Ref: A/146/19/PL

Proposal: Demolition of existing storage building and erection of a three bedroom chalet bungalow with associated parking and landscaping

Location: Land rear of 1 The Heathers Arundel Road Angmering BN16 4LE.

Proposed Bungalow Plans and Elevations

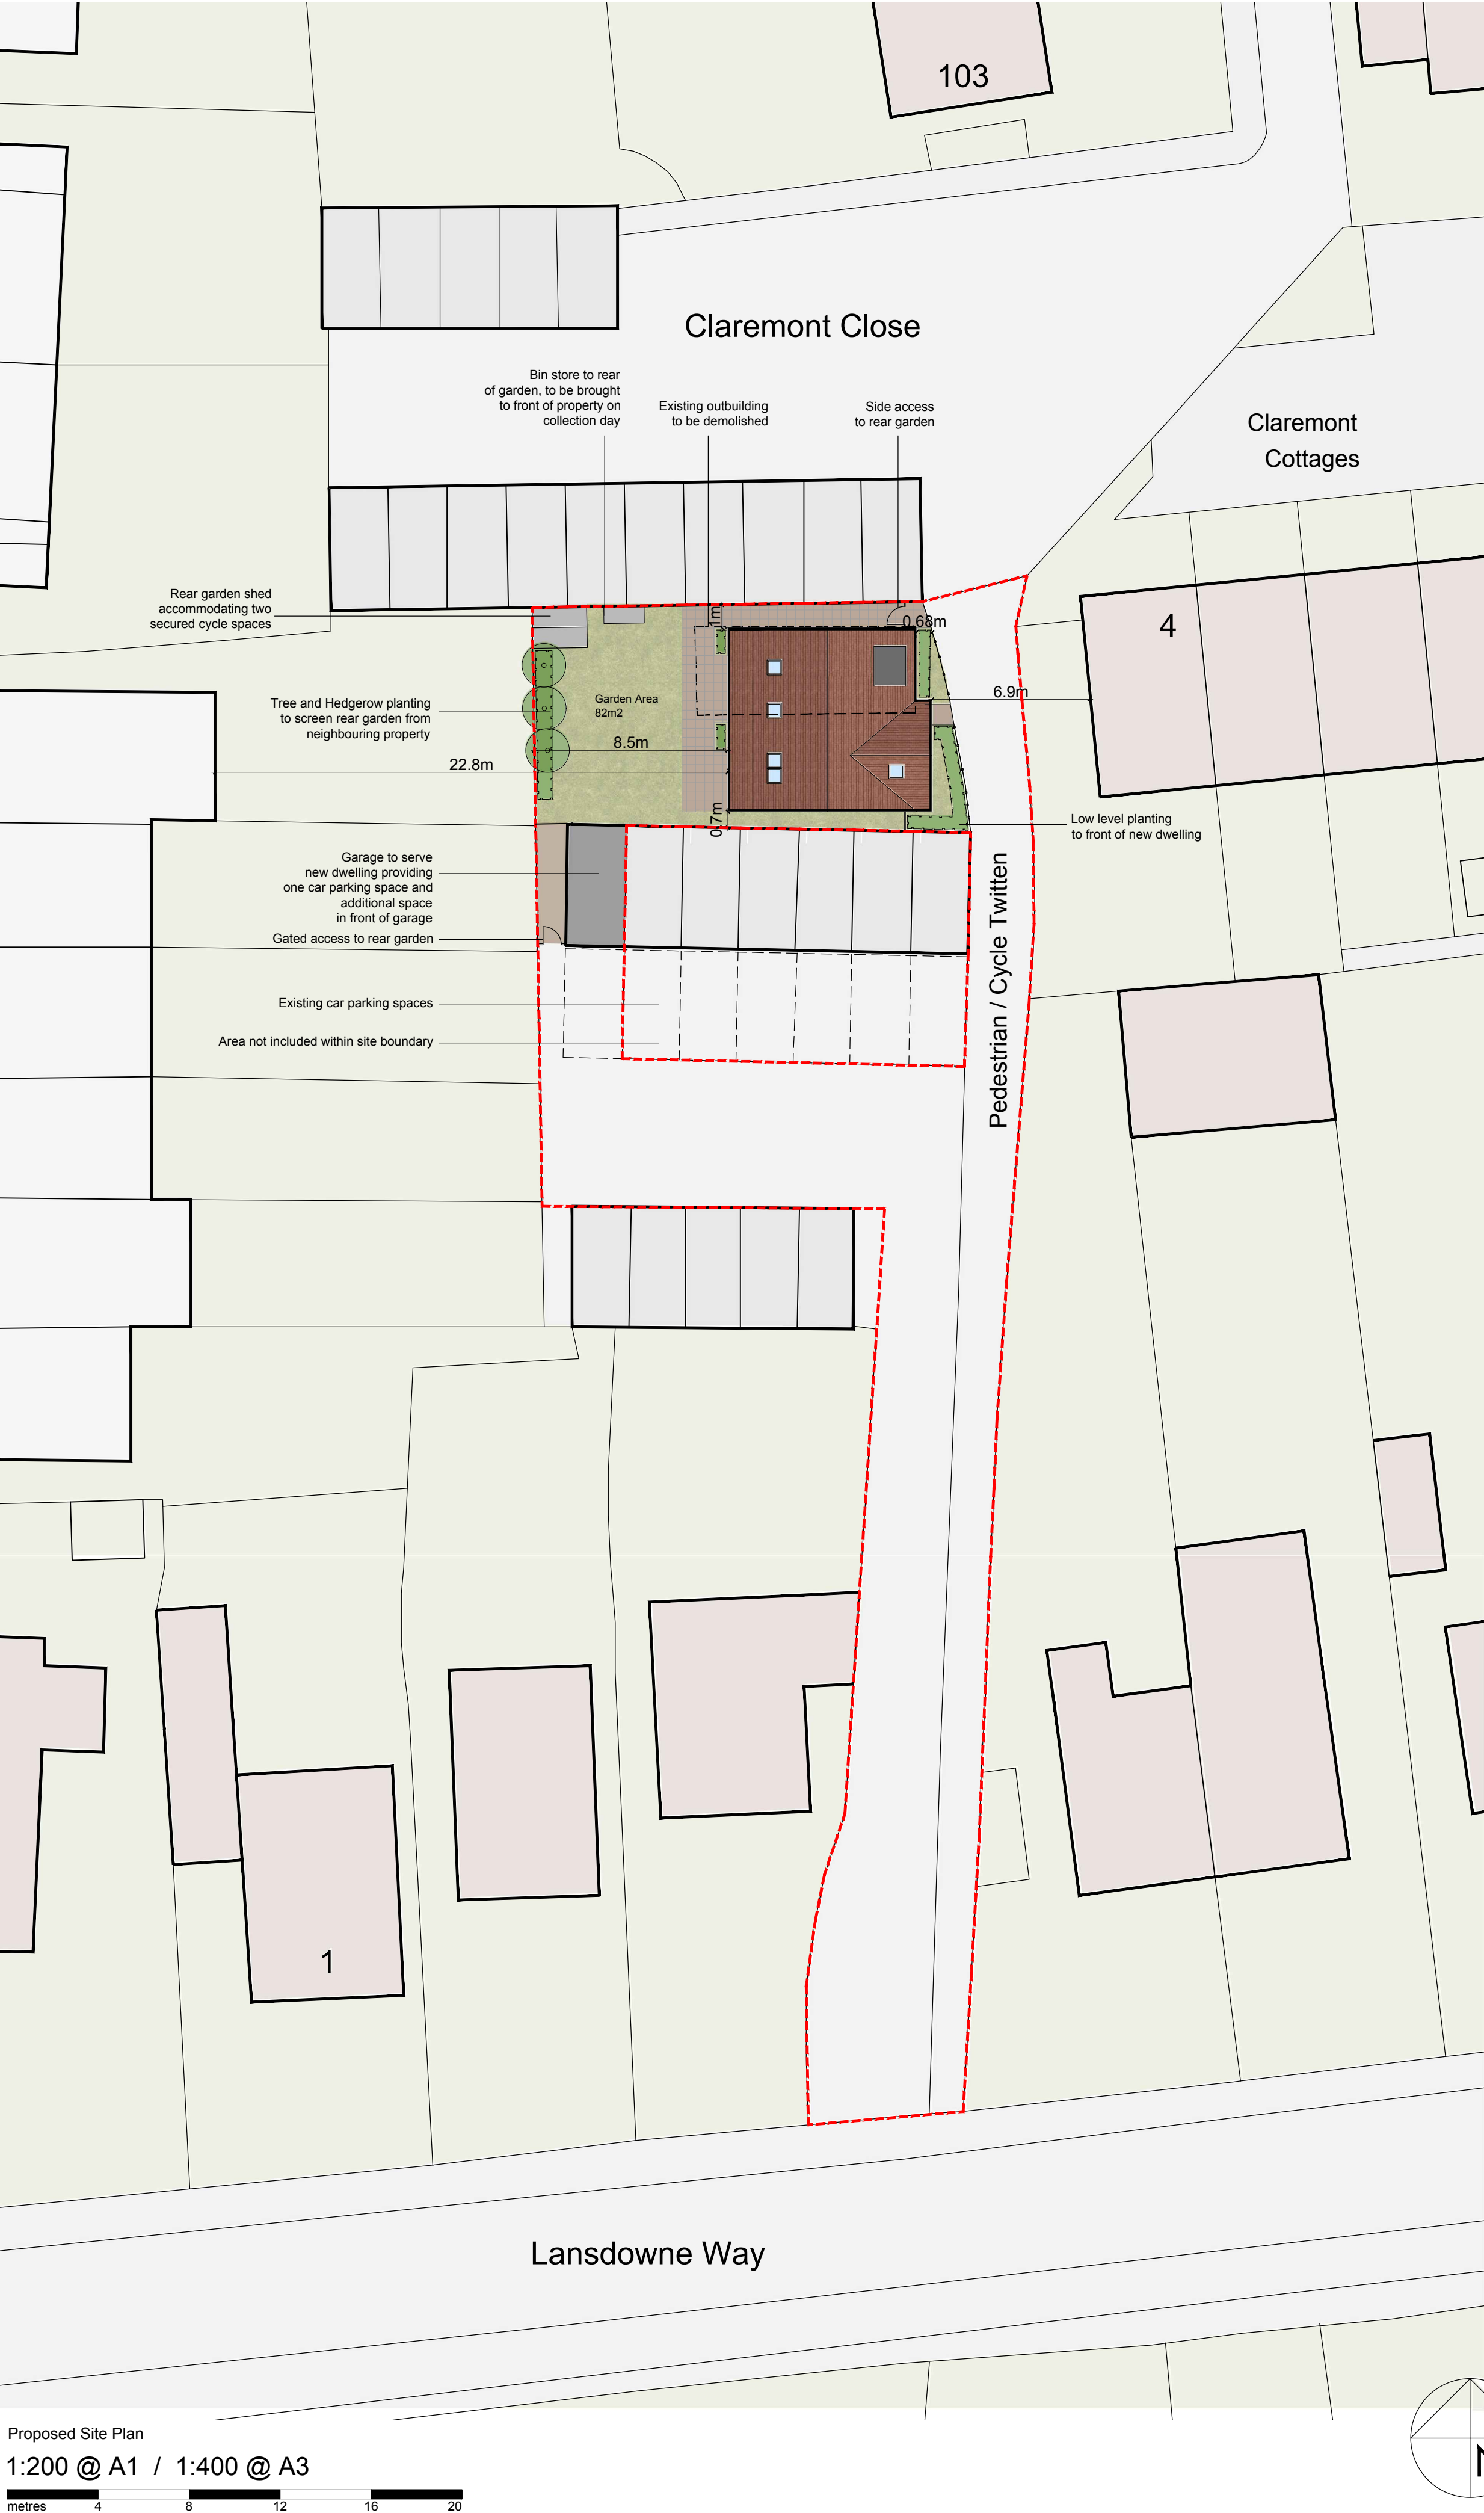
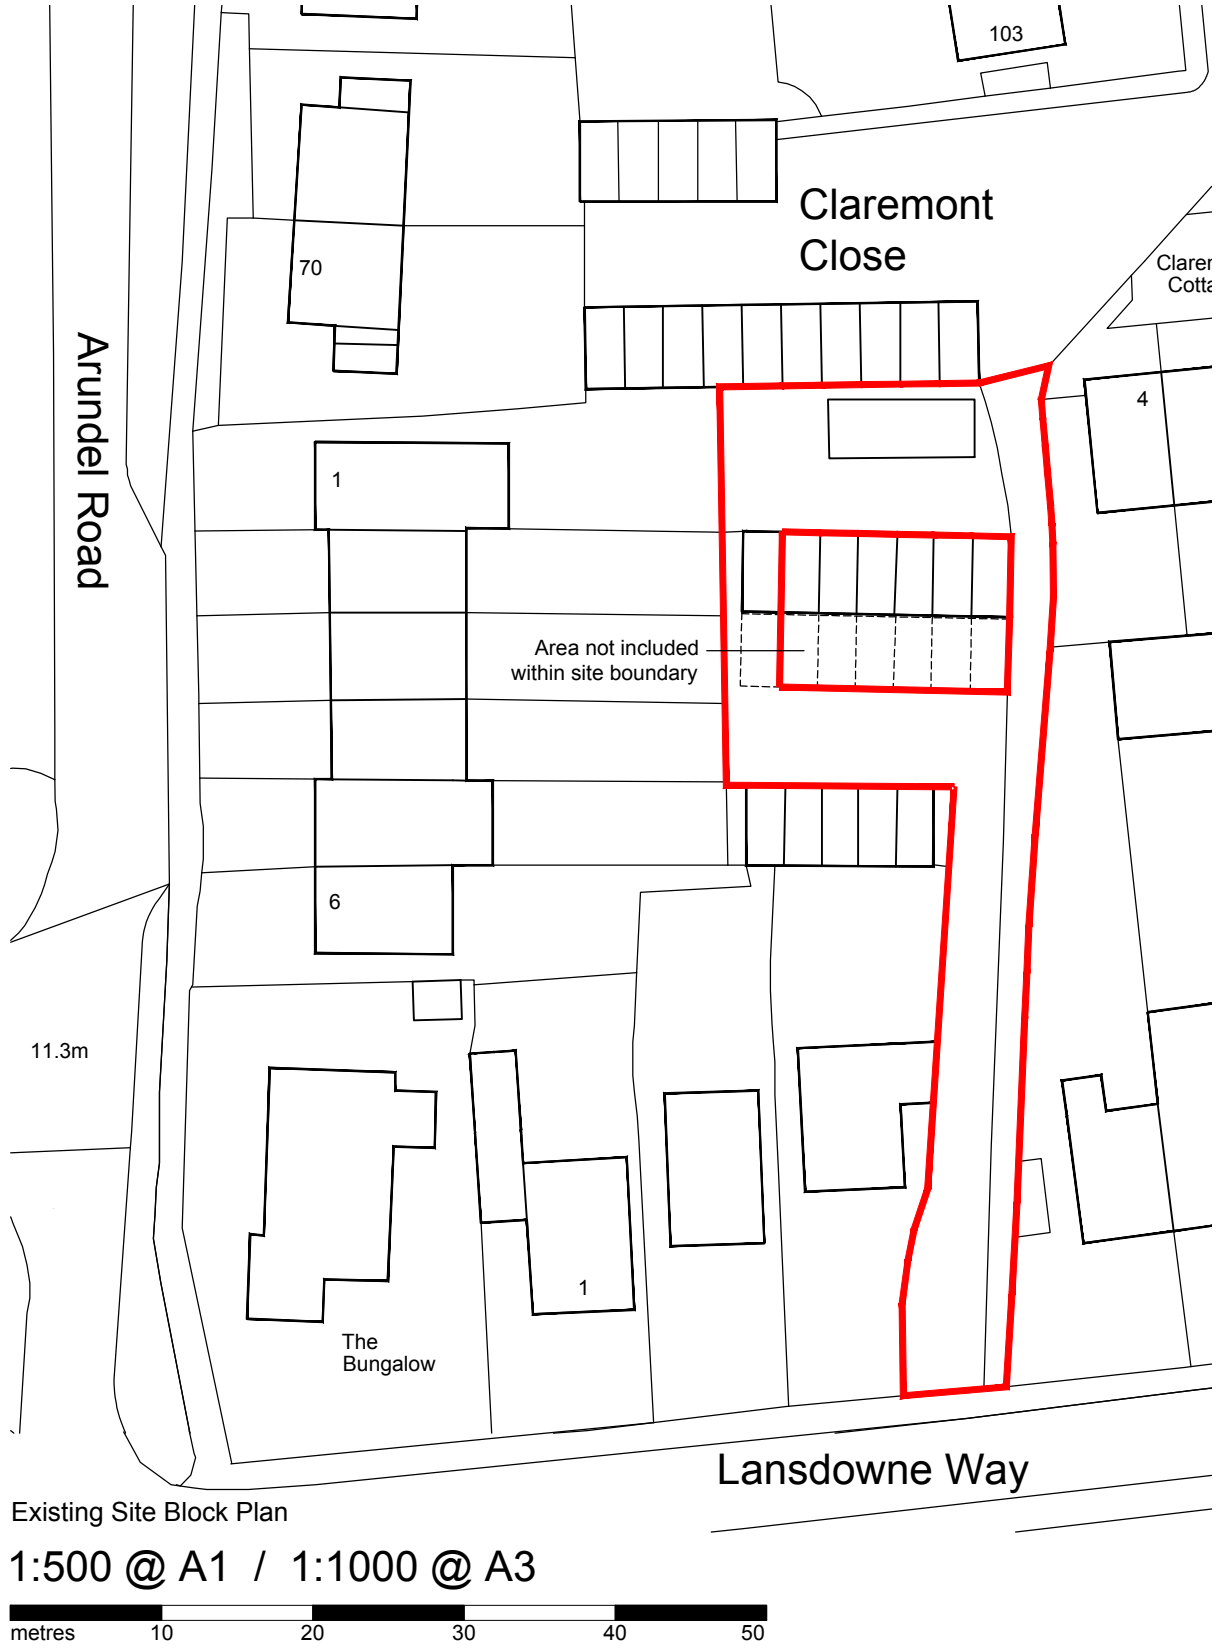
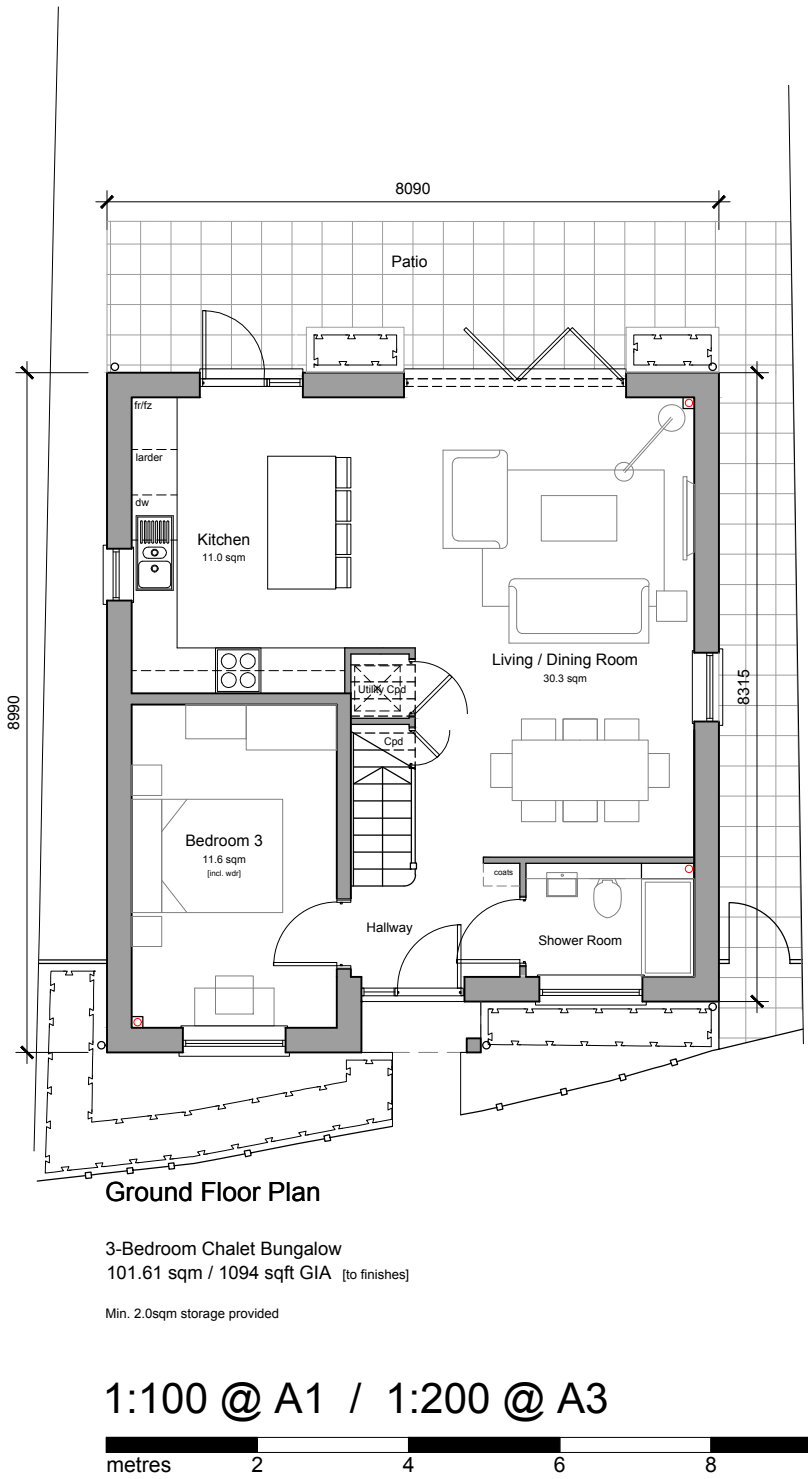
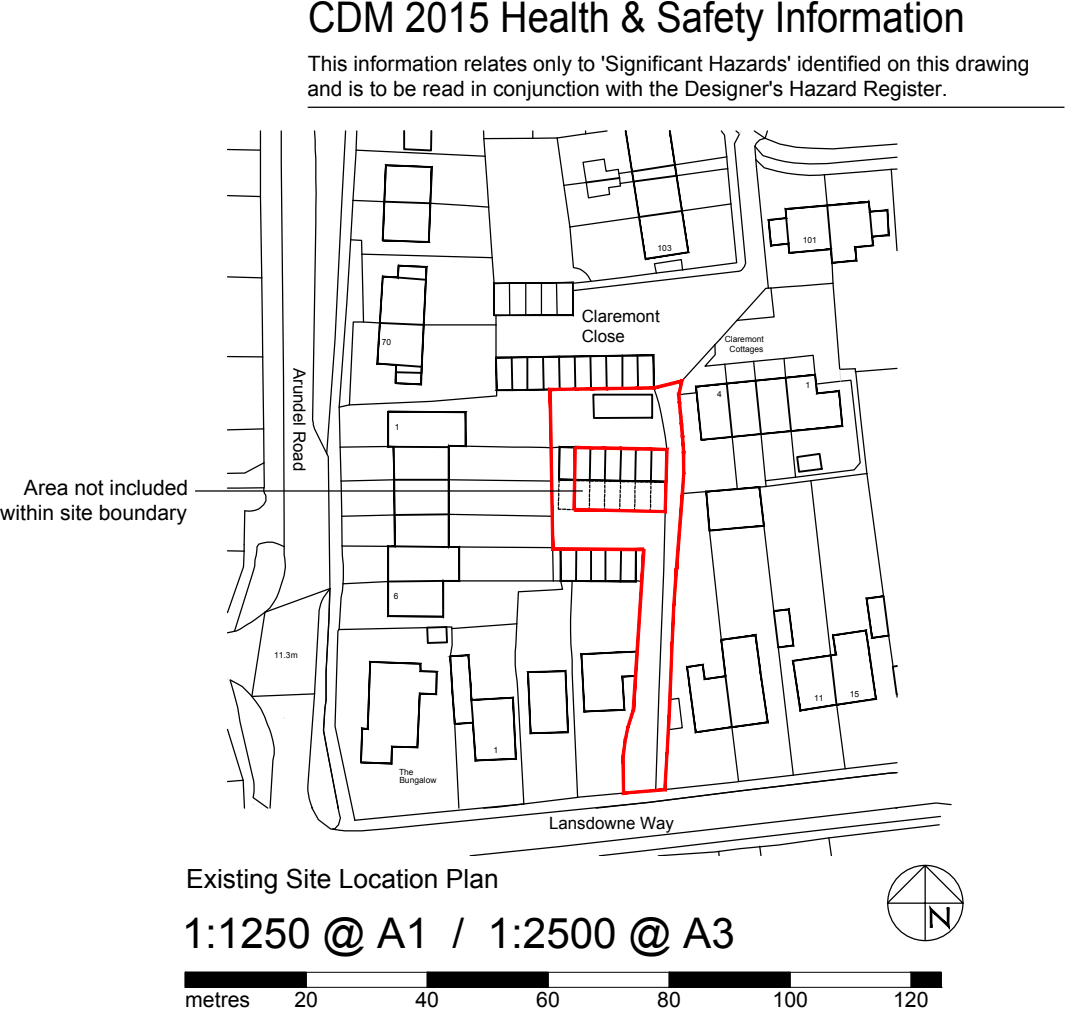
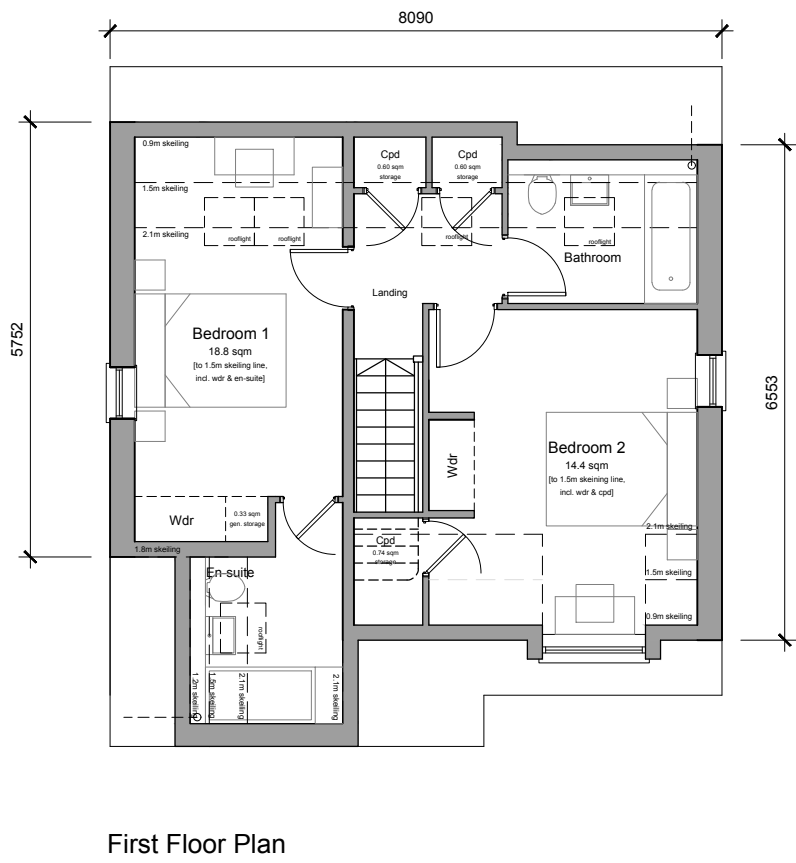
I believe the proposal of a three-bedroom chalet house would be too large for the site. The footprint shows significant increase from the existing outbuilding which is only a single storey. Store and already dominates the site. Therefore, not appropriate for this site. The height of the proposed plan is effectively two stories high and in close proximity to neighbouring properties so will overlook them.
